Technical Memorandum

| Subject | Grading Plan Review for Ellwood House Development at 2262 Braeside Avenue, Ottawa, Ontario | | |

This technical memorandum provides a summary of the grading plan and engineering design review for the proposed Ellwood House development at 2262 Braeside Avenue (herein after referred to as “the site”) in Ottawa, Ontario.

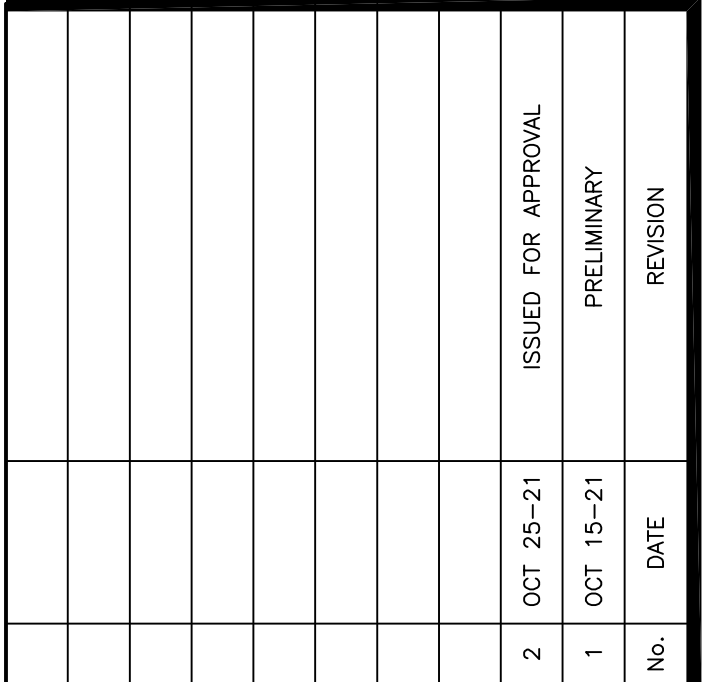
Table 2.1 summarizes the proposed grades at different corners of the proposed structure. According to these drawings, and the proposed finished grades, grade raises of up to 0.91 m is being considered near the proposed structure.

Based on the results of the geotechnical investigation, silty clay was not encountered at any of the boreholes advanced within the site. Therefore, from a foundation design perspective, no practical restrictions apply to the thickness of grade raise fill that may be placed within the proposed residential development area. Accordingly, no light weight fill is required.

In addition, there would be sufficient earth cover over the footing bearing surfaces for the house (i.e., greater than the 1.5 m required for frost protection) at this site.

It is understood that underside of footings is being proposed at elevation 98.3 m. Based on the previous geotechnical investigation, the subgrade will consist of fill material at this elevation. The surficial fill material and topsoil are not suitable for support of the foundation loads and should be removed from the foundation areas. Where required, Engineered Fill could be placed below a footing to raise grades to the design footing level. The Engineered Fill should consist of Granular B Type II and must be placed in maximum loose lift thicknesses of 0.2 m and compacted with suitable vibratory compaction equipment to 100 percent SPMDD. Engineered Fill for support of foundations should be placed extending downwards and outwards from the edge of footing at 2 horizontal to 1 vertical.
